Appeal Decision

Appeal Ref: 6001250

42A Station Road, Fenay Bridge HD8 0AD

- The appeal is made under section 78 of the Town and Country Planning Act 1990 (as amended) against a refusal to grant planning permission.
 - The appeal is made by Gary Oldroyd against the decision of Kirklees Metropolitan Council.
 - The application Ref is 2025/62/91627/W.
 - The development proposed is the erection of extension.
-

Proposed Elevations

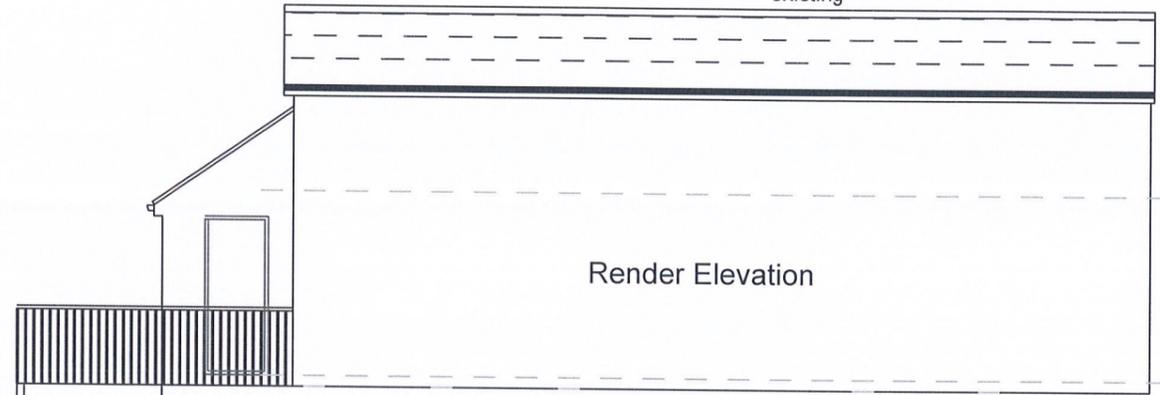
4. The appeal relates to a detached split-level dwelling set back from Station Road. The proposed extension would alter the simple form and footprint of the property, with the dual-pitched addition creating an L-shaped building. While the ridge height would remain consistent with the existing dwelling, the raised eaves would allow

for additional first-floor accommodation. Although the extension would be shallower than the host building, its span across the ridge line would be greater. As a result of its scale and form, the extension would not fully reflect the character or proportions of the host dwelling. The changes would be readily visible from within the appeal site and, to a lesser extent, from within garden areas of immediate neighbours, including 44, 46 and 48 Station Road. Nevertheless, the overall design is considered to respond appropriately to the site's context and would achieve an acceptable degree of cohesion with the existing building, ensuring that the extension would not appear unduly ostentatious.

5. The lack of subservience would not result in harm to the appearance of the property or appear overly cramped within the plot. The introduction of composite cladding boards would add a contemporary material not widely used in the surrounding area. However, their application would be restricted to only parts of the extension, and as such they would not be highly prominent.

7. From lower vantage points within the valley, views from the west would be directed towards the partially clad and glazed gable end of the proposed extension, as well as the altered rear fenestration and proposed balconies. Taken together, the changes to the rear elevation would not appear incongruous in the wider hill-scape. Moreover, given the largely oblique and interrupted nature of views in this direction, the scheme would not be clearly visible.

10. The use of obscure glazing to the window on the east-facing elevation and above eye level velux–vertical combination windows on the north-facing elevation, are appropriate design responses. These measures would ensure that any potential overlooking is suitably mitigated.
11. Although the development would alter the view currently enjoyed from neighbouring properties, the planning system does not safeguard private views. The key consideration is whether the proposal would result in an unacceptable impact on outlook or appear overbearing. For the reasons set out, the proposal would not give rise to such harm.
12. The potential for the development to impact on sewerage pipes is outside the scope of the appeal, so it has not influenced my decision. In addition, there is no substantive evidence that the development would result in damage to a neighbouring tree or cause any erosion.

Site Plan & Roof Plan		
Fenay Bridge		
HD8 0AD		
Date	May 2025	Dwg no 05
Scale	A3 - 1:200	
Dwn By	-----

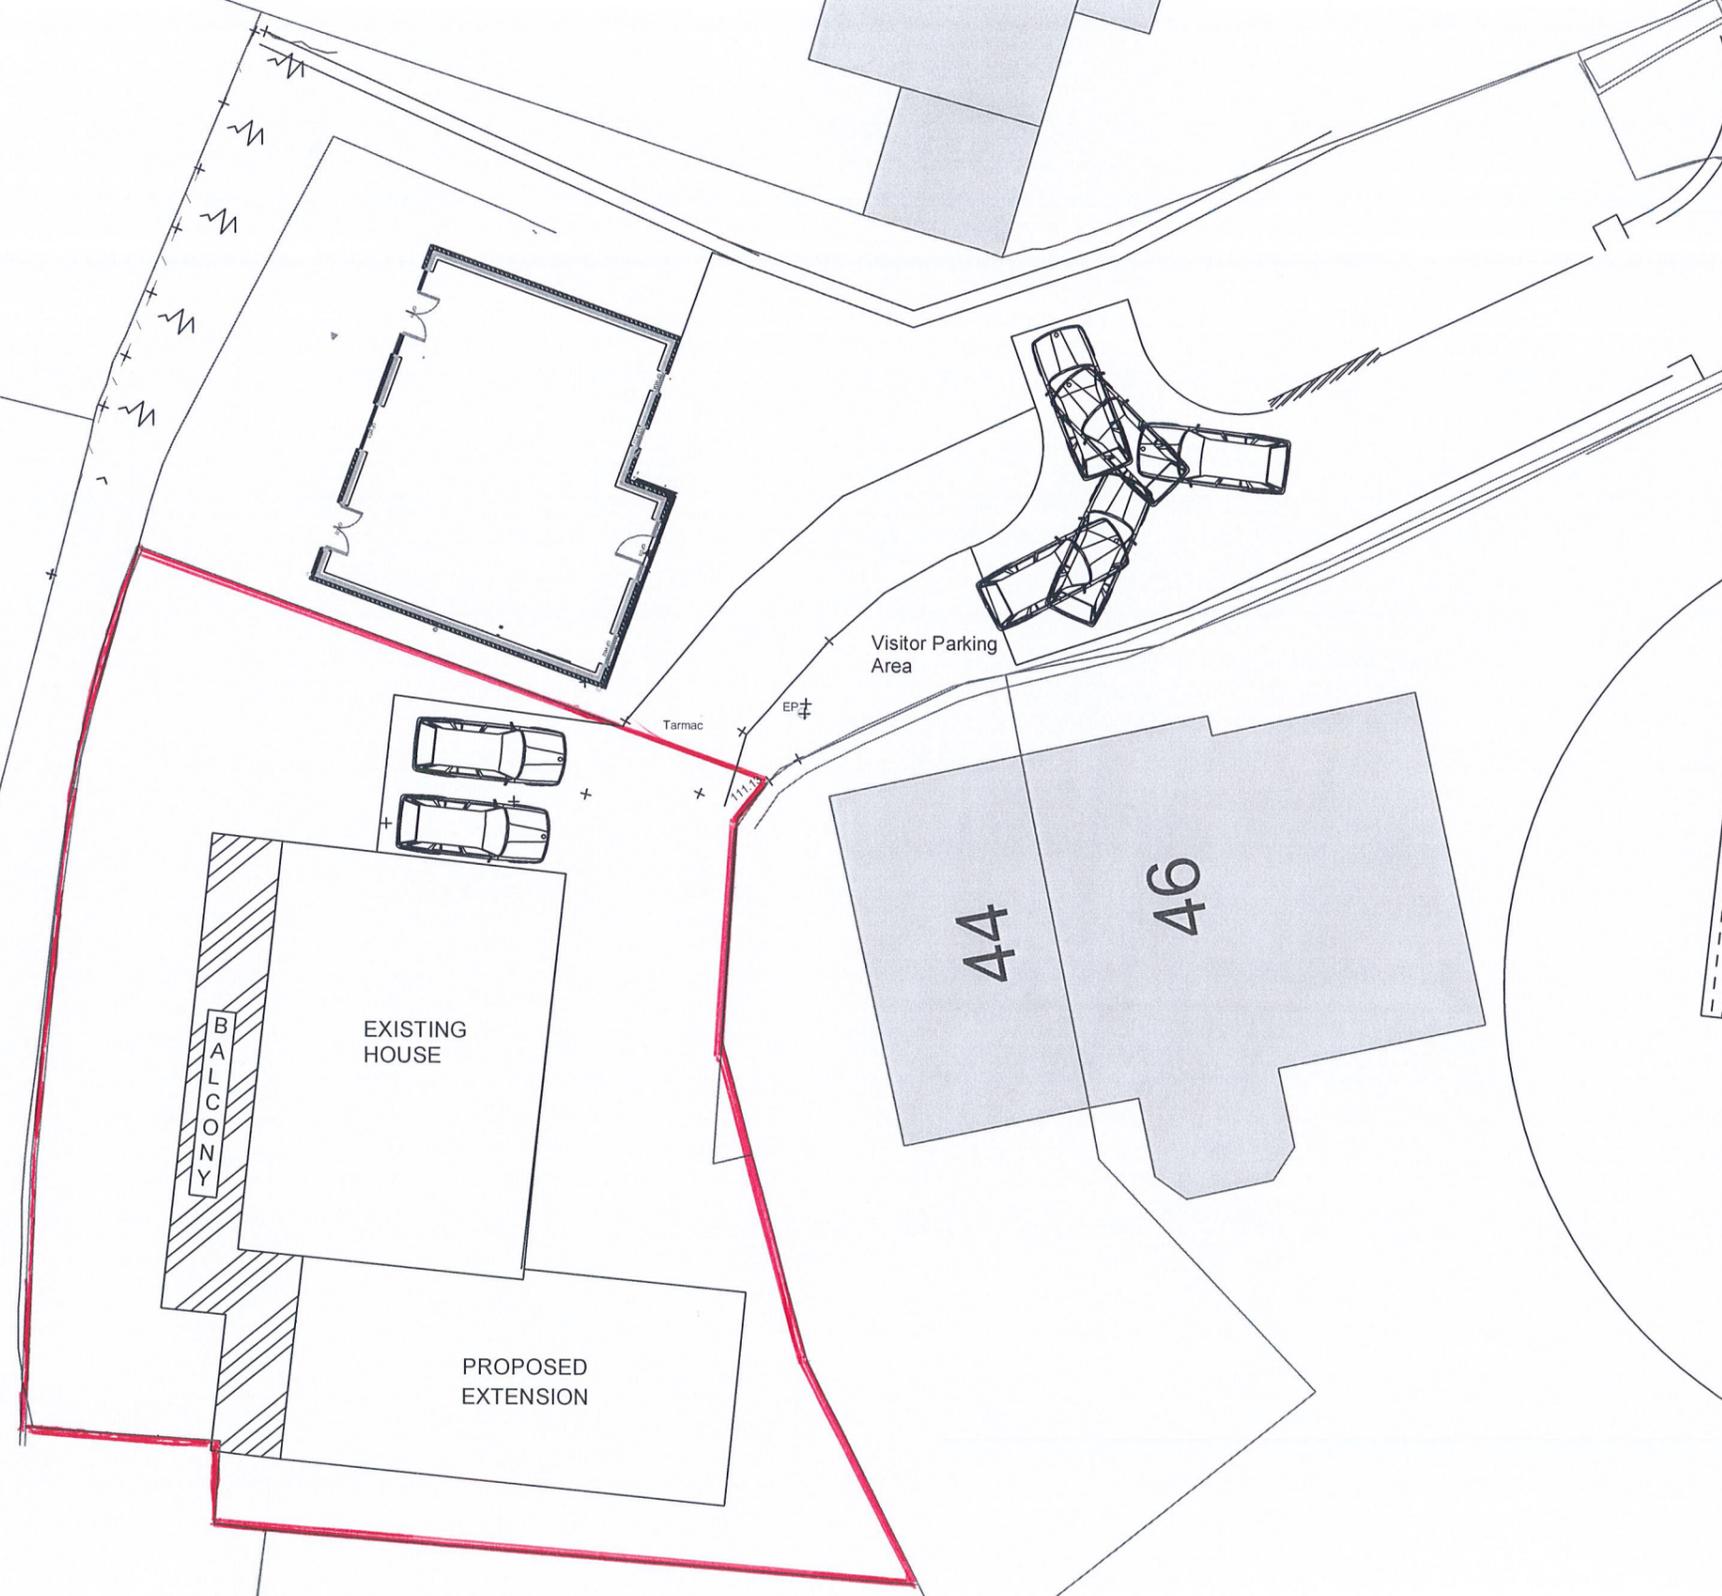
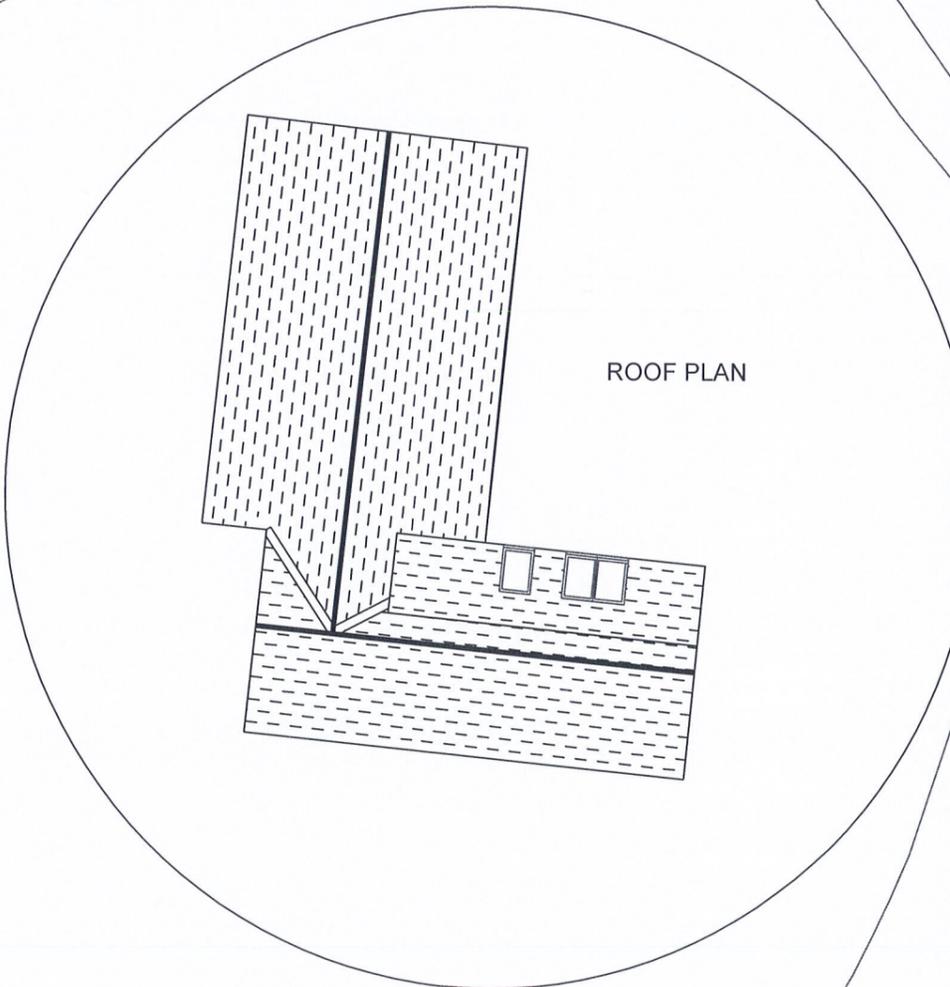
6. Due to the extension's position within the site and its hillside setting, it would be largely screened by neighbouring properties, particularly 44 and 46, in viewpoints along Station Road. Partial views would capture the upper roof within the wider roofscape, and the use of matching roof tiles would effectively assimilate it into its surroundings. Furthermore, given the varied composition and character of dwellings in the vicinity, the proposal would not disrupt any established building line or pattern of plot density within the street scene.

9. The ground level along the shared boundary with No 44 is notably lower within the appeal site, thereby reducing to an acceptable degree the amount of the extension that would be visible from within the neighbouring garden and appearing above the retaining wall and boundary fencing. In addition, given the relative orientation of the rear garden at No 44, any resulting shadowing would be limited in both extent and duration. Accordingly, the development would not have an overbearing effect
